From  
The Member-Secretary,  
Chennai Metropolitan  
Development Authority,  
Thalamuthu Natarajan Maligai,  
8 Gandhi Irwin Road,  
Chennai-600 008.

Letter No. B2/6476/97

Sub: CMDA - APU - PP - construction of CR + 3P

of Residential Bldg at D No 37, Iyer Main Rd,  
Raja Annamalai pura - R.S No. 3927/34  
of Mysore - Chennai - 28 - District of DCA  
Ref: Your PPA dt 19.3.97

SECTION X-X

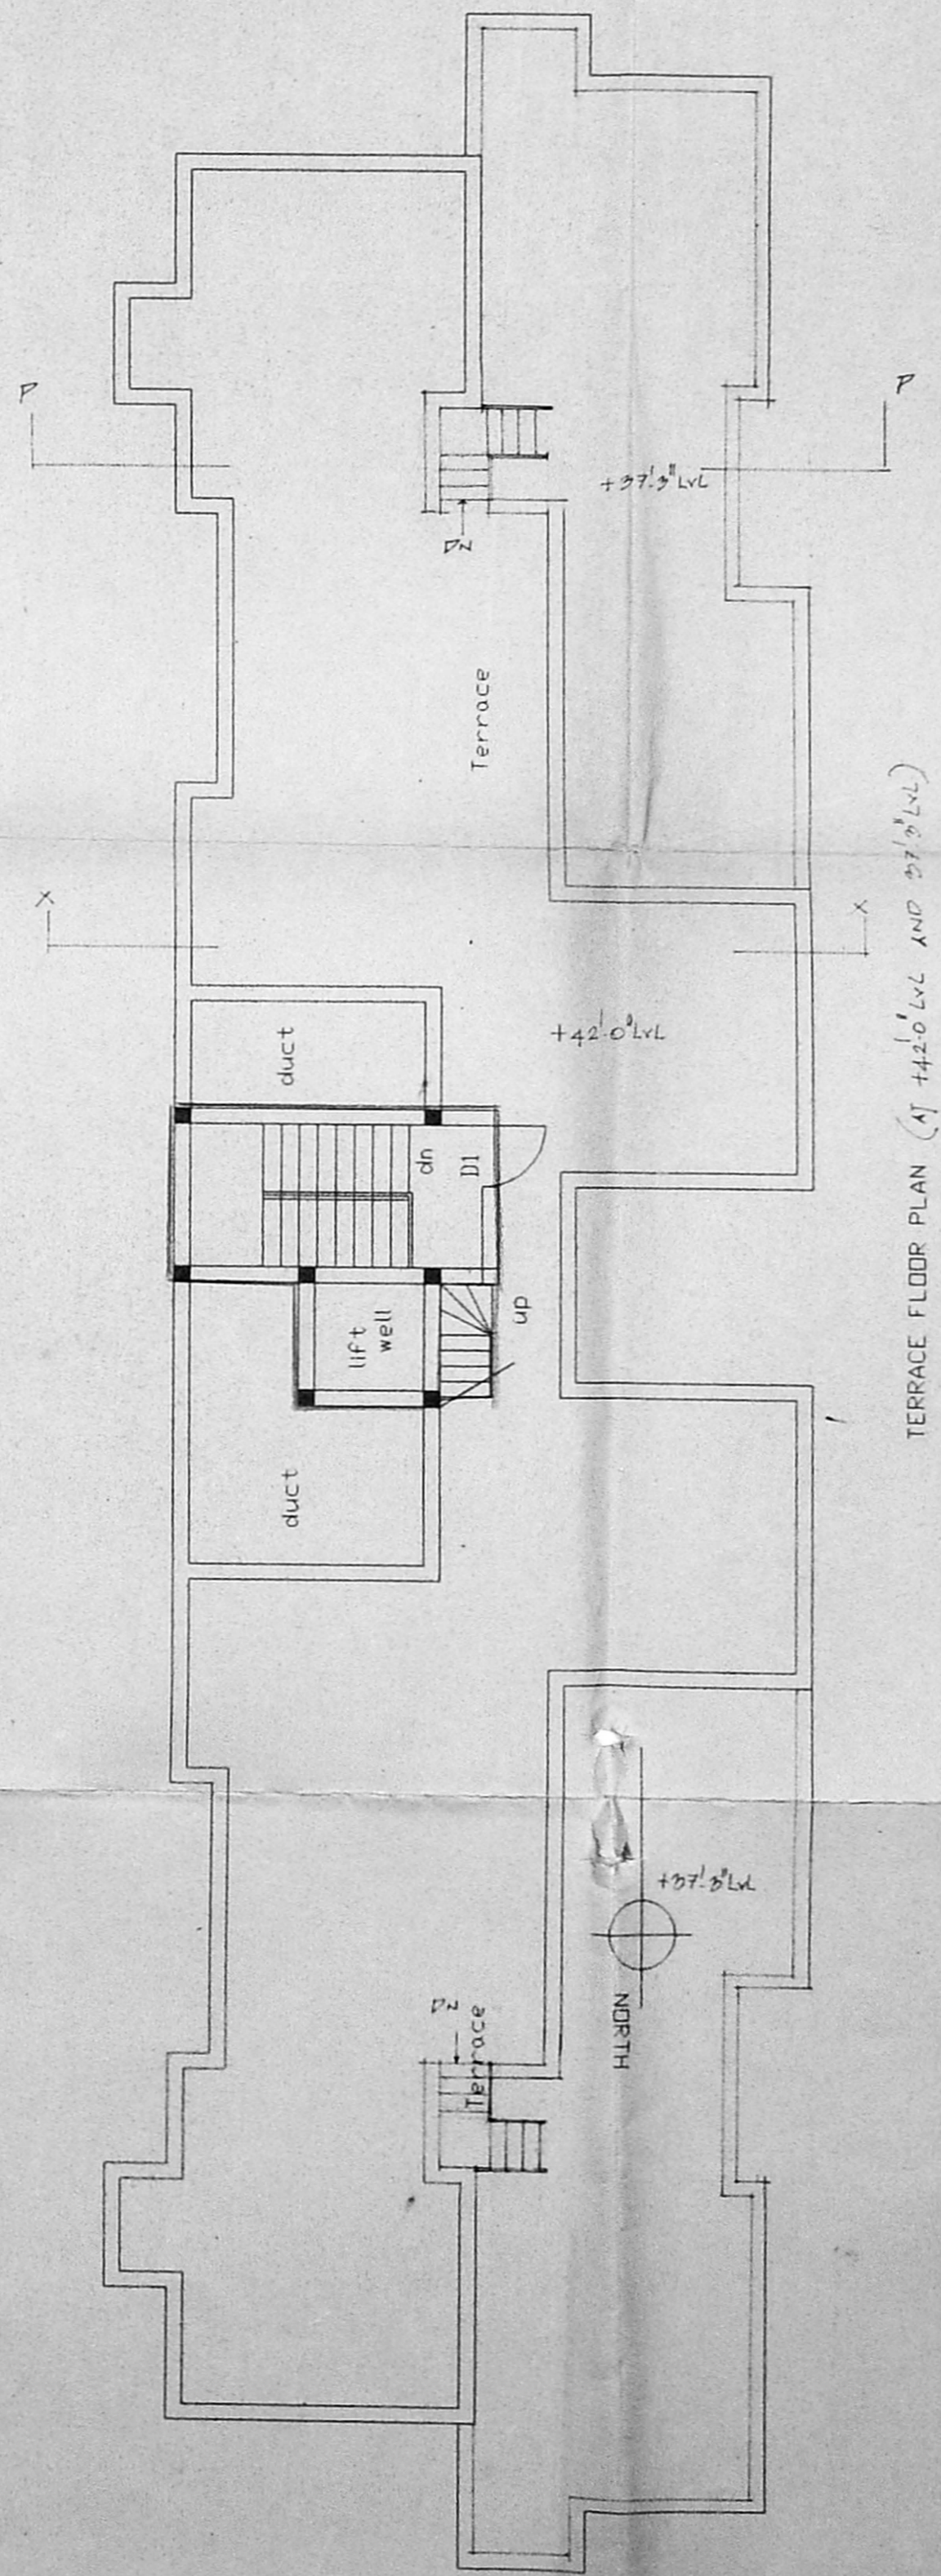
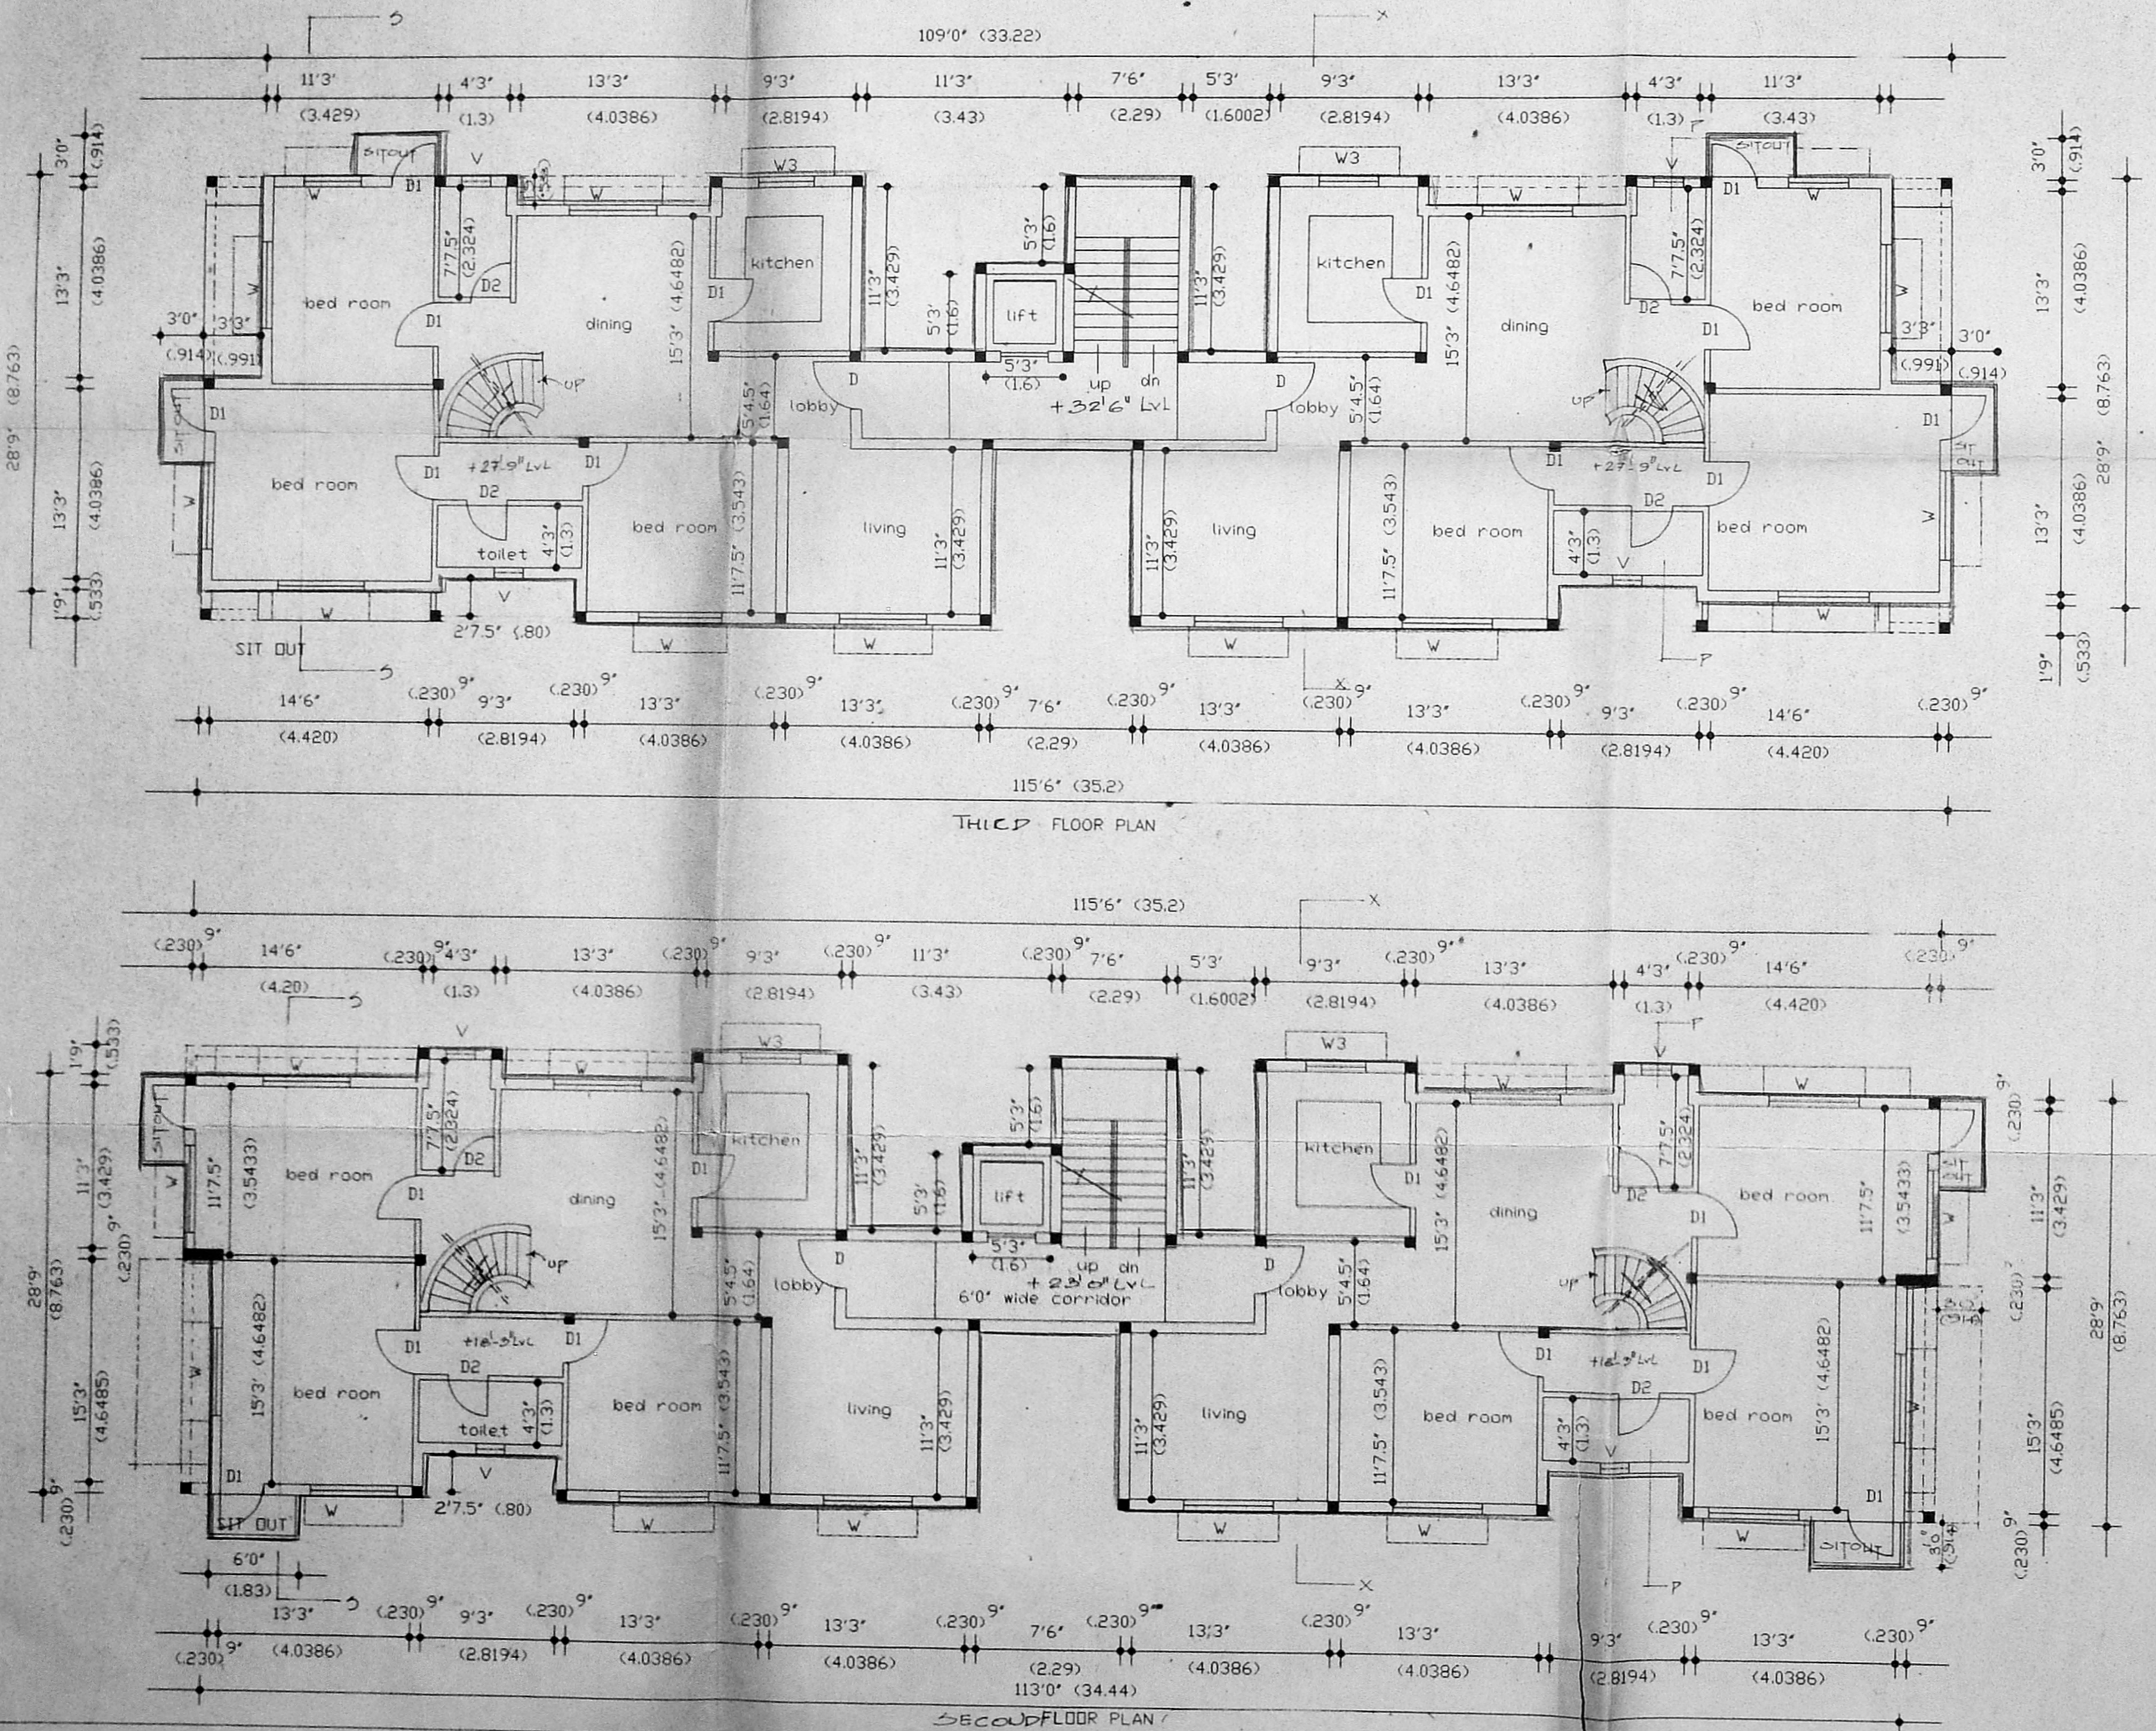
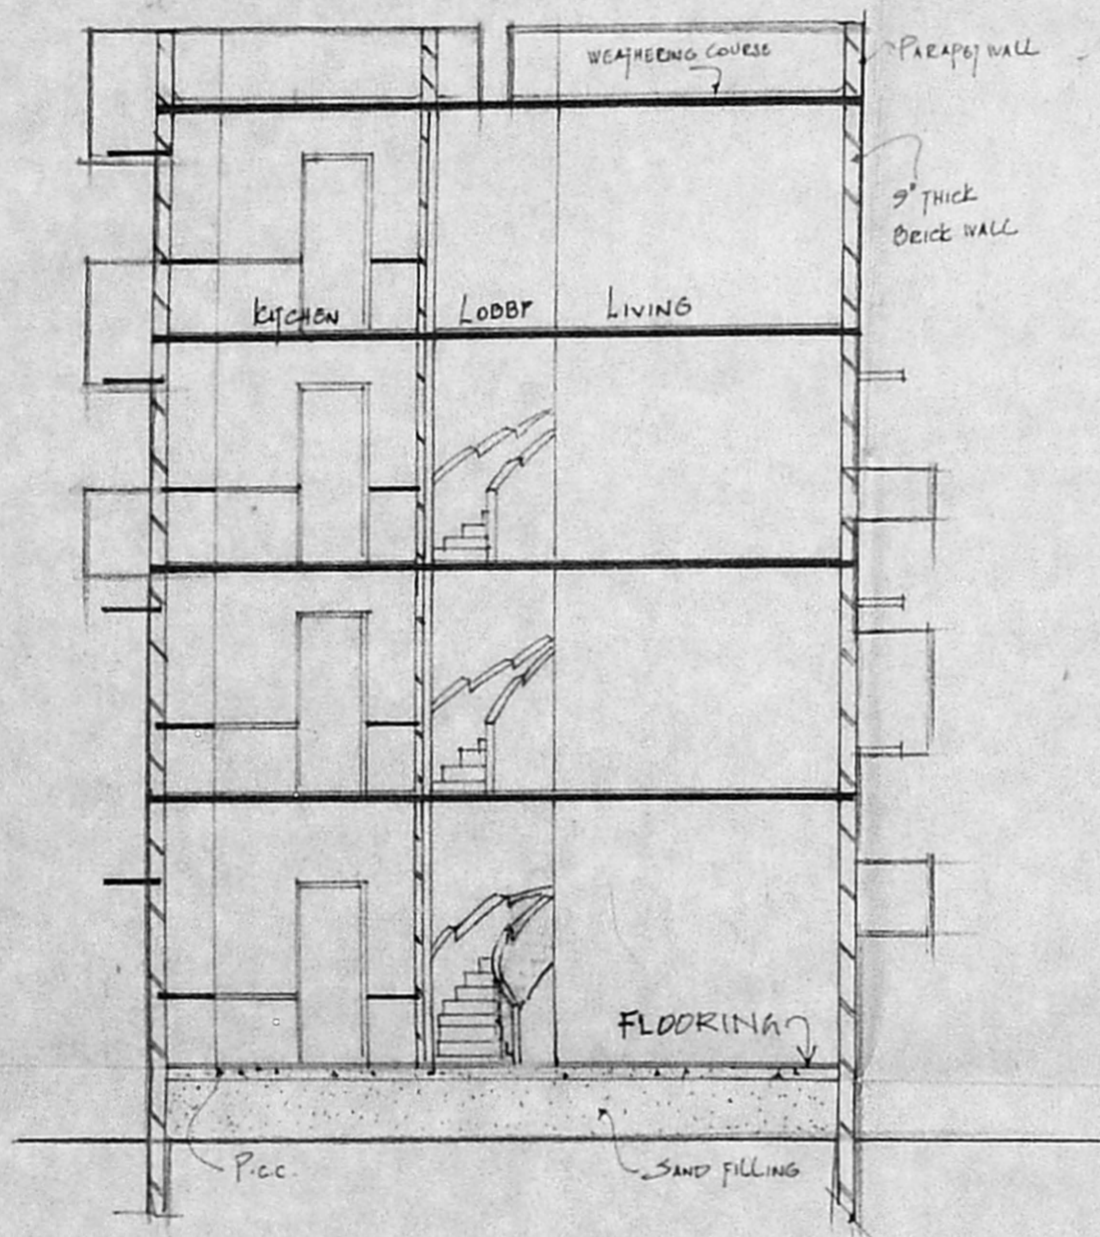
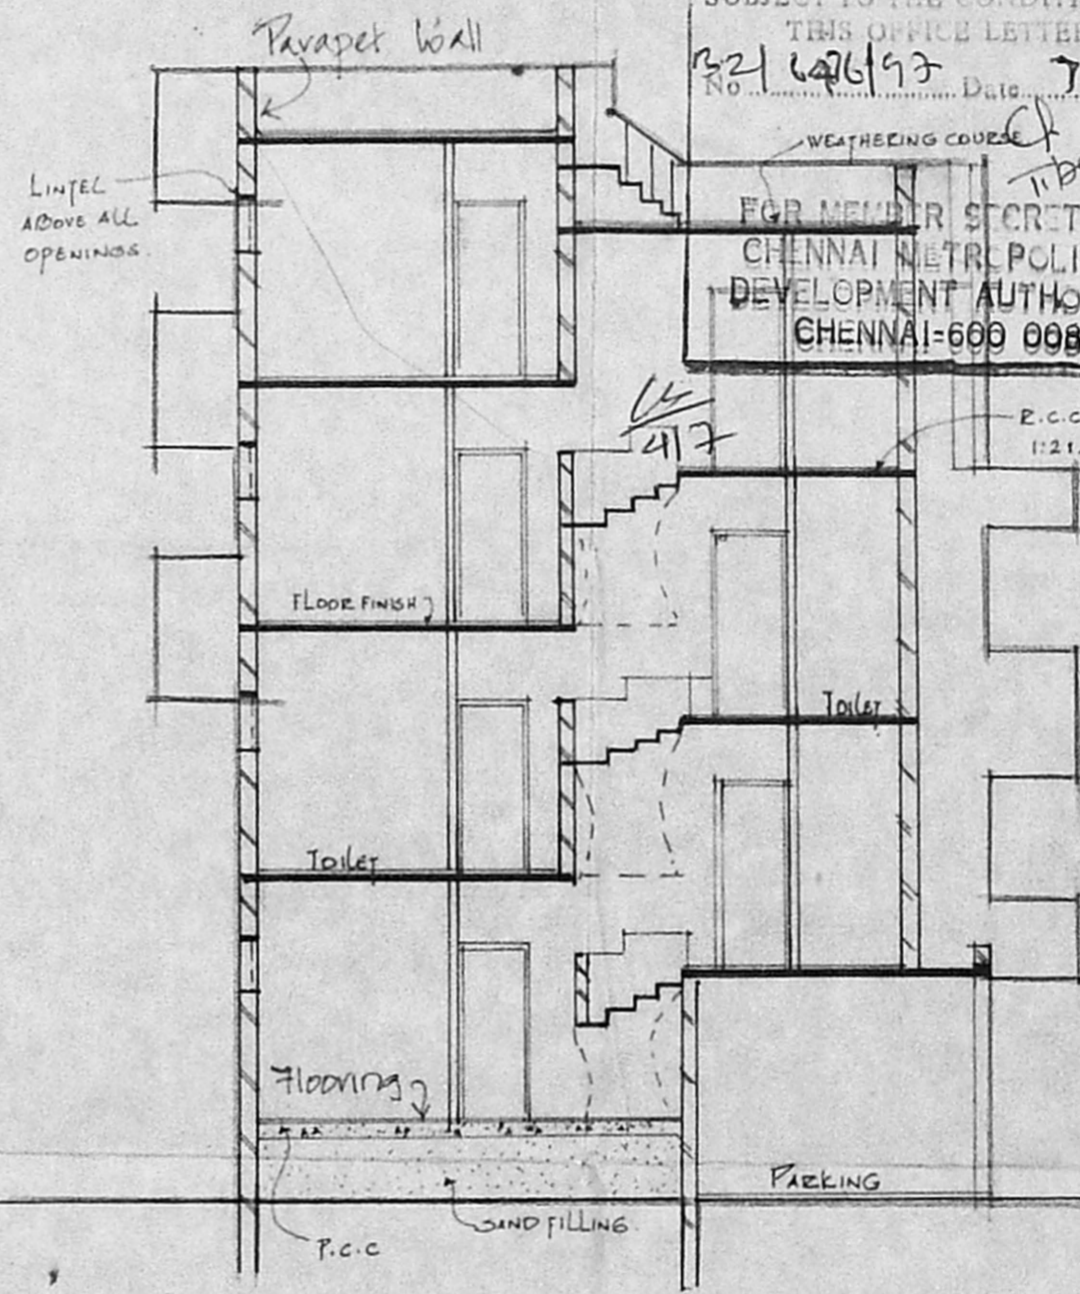
- Handwritten notes:*  
 Revised plan not correct. 16.5 - Split level Rence Title 4  
 c) i) be corrected.  
 (ii) parking Ht shows 2.47 including slab thickness it is less than min reqd. Rence clear Ht of 2.40m to be provided.

- (iii) There is no adequate Rence room provided at the end of split level floors ~~Rence~~ to be provided.
